OXFORDSHIRE COUNTY COUNCIL'S RESPONSE TO CONSULTATION ON THE FOLLOWING DEVELOPMENT PROPOSAL

Application no: 21/03177/F

Proposal: Full planning application for employment development (Use Classes E(g)(iii), B2 and/or B8) and associated parking and servicing, landscaping and associated works

Location: Axis J9 Phase 3 Howes Lane Bicester

PHASE 3 External Works & Levels

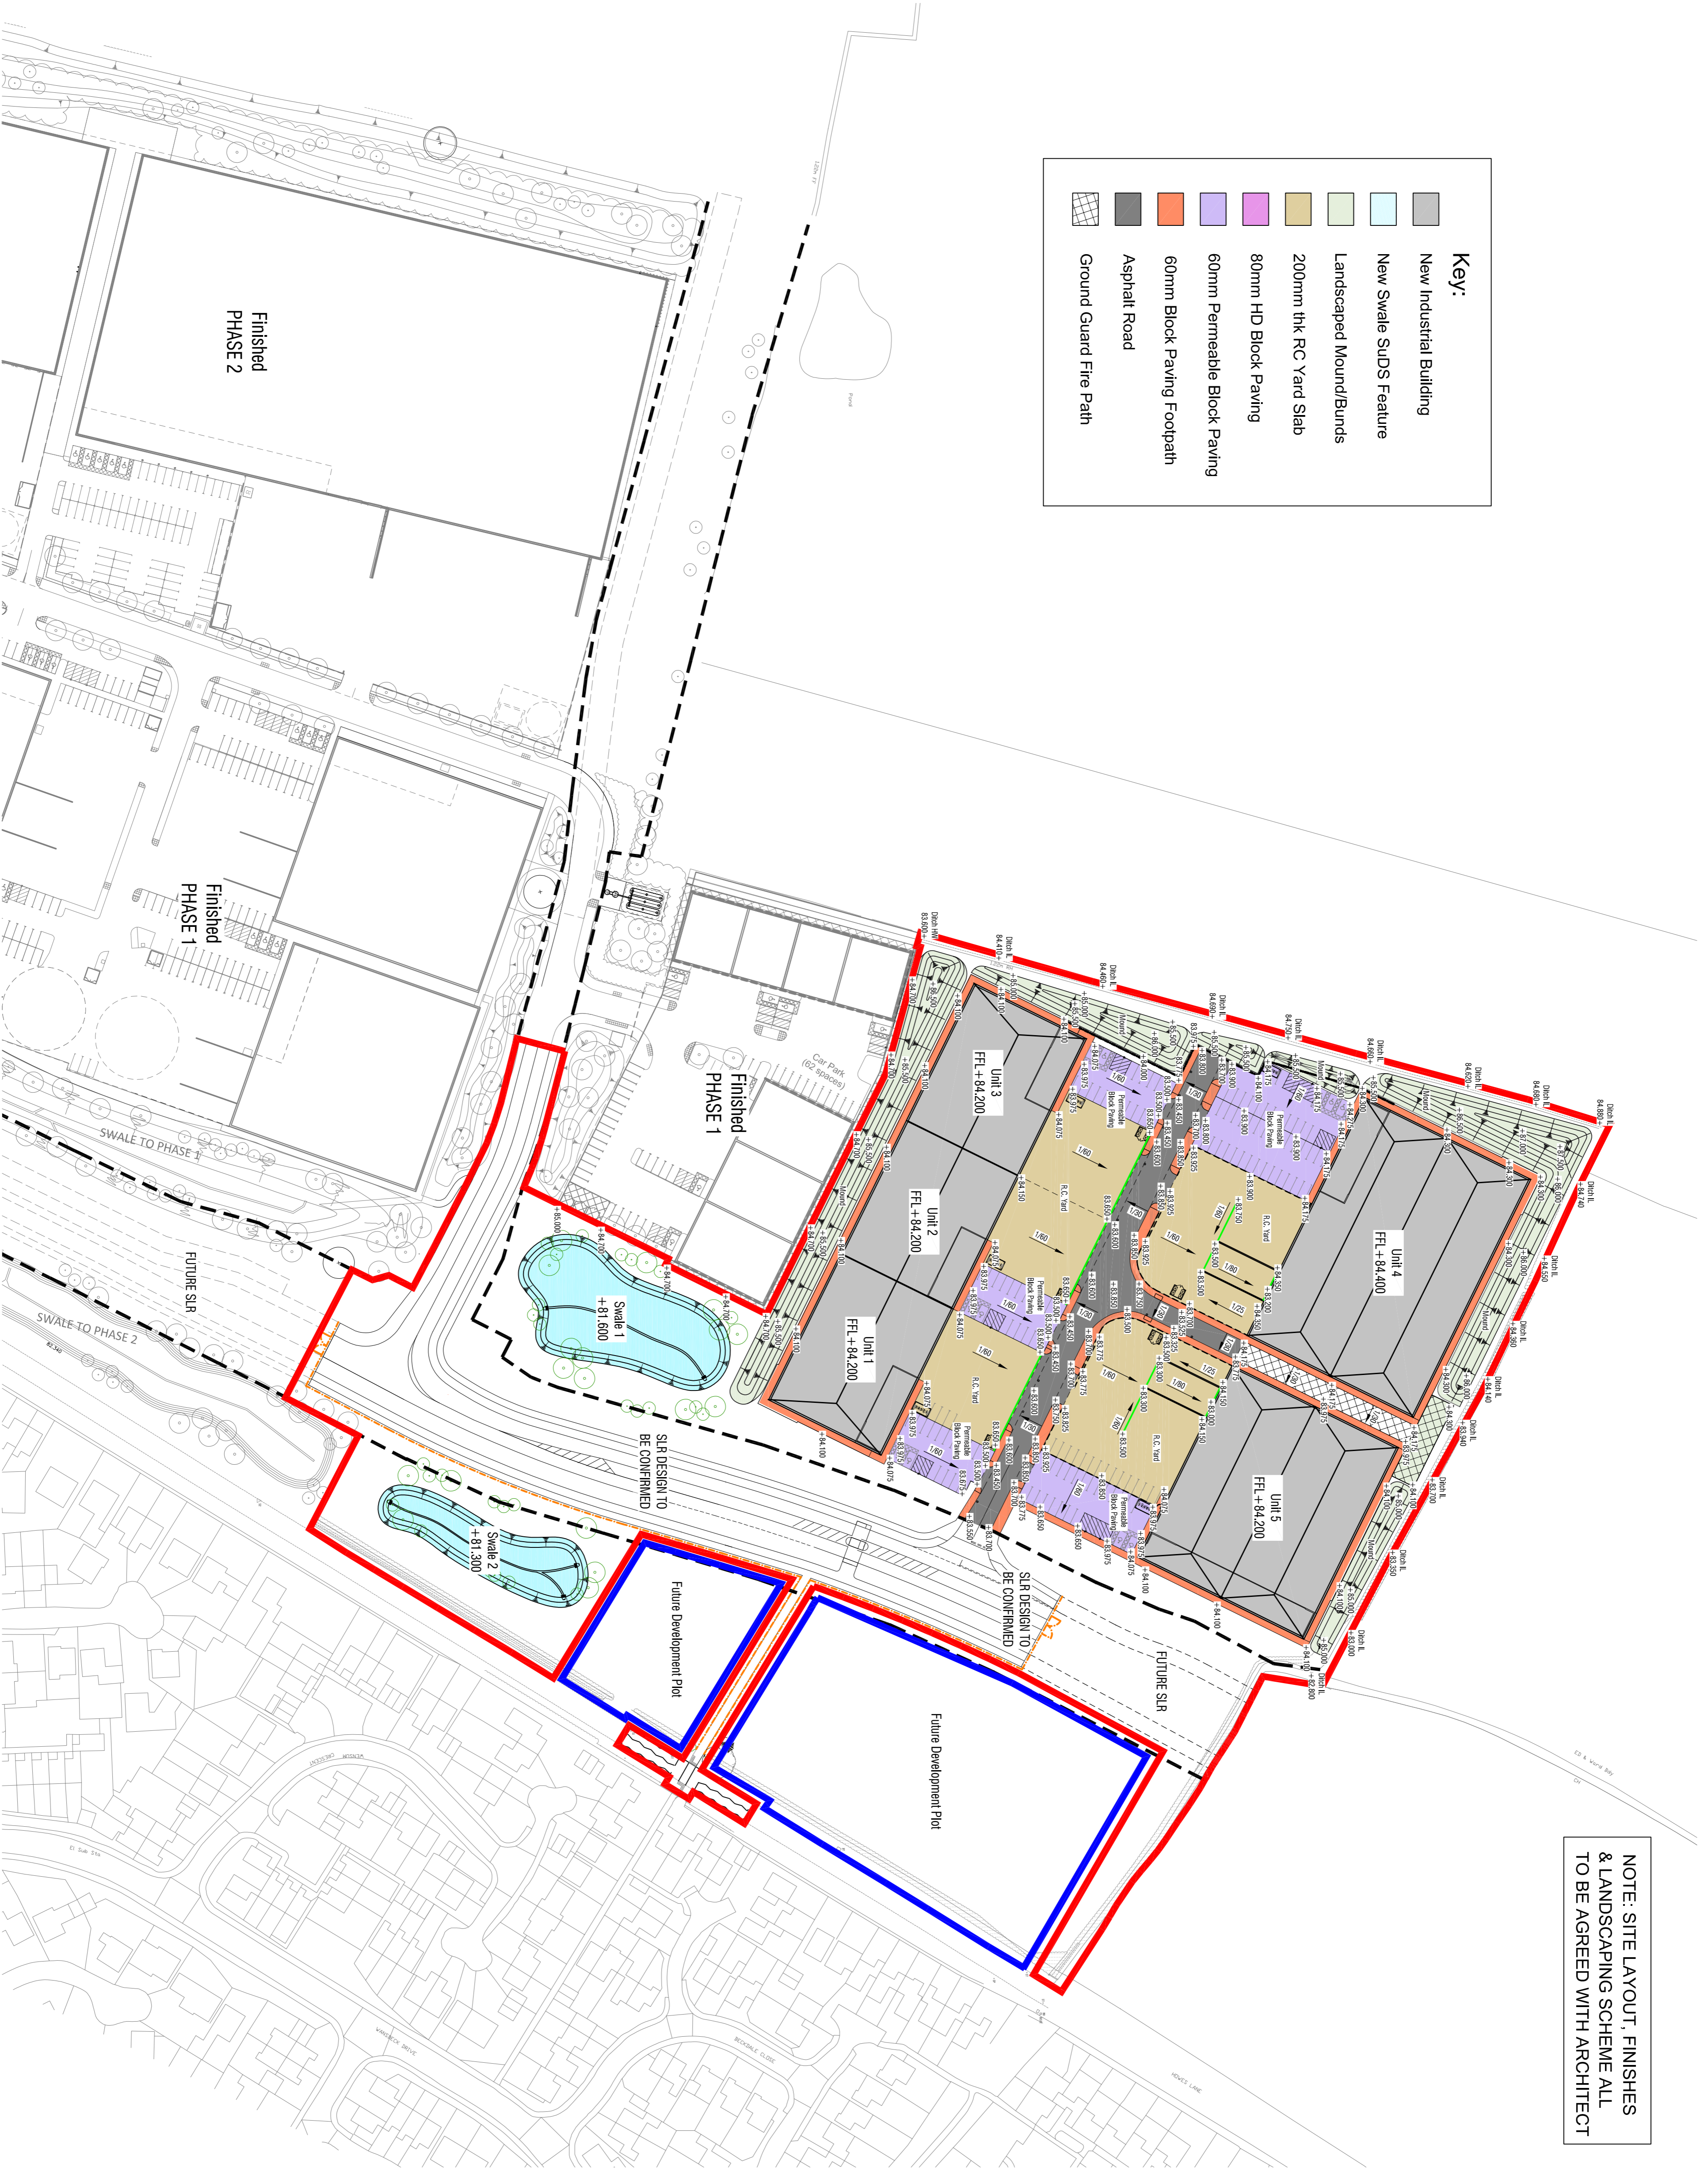
Surface water catchment plan does not include the whole site, for instance the main road has not been included.

There are proposals within the application boundary that has not been included in the drainage strategy. From the architects layout there are many hard standing areas that has no drainage strategy, for instance the road that is going around phase 1 and 2.

Plan drawing shows headwall discharging to an green hatched area. This has not been denoted on the key.

Ownership of culvert and permission to connect to be provided. Capacity of the culvert to be confirmed and the surface water that its currently taking .Also its mentioned the culvert will be upgraded, provide clarification of what the upgrade will include and when this will be done. Ideally it should be upgraded before phase 3 is developed to reduce the risk of flooding in neighbouring sites. Provide correspondence from the relevant party confirming the above.
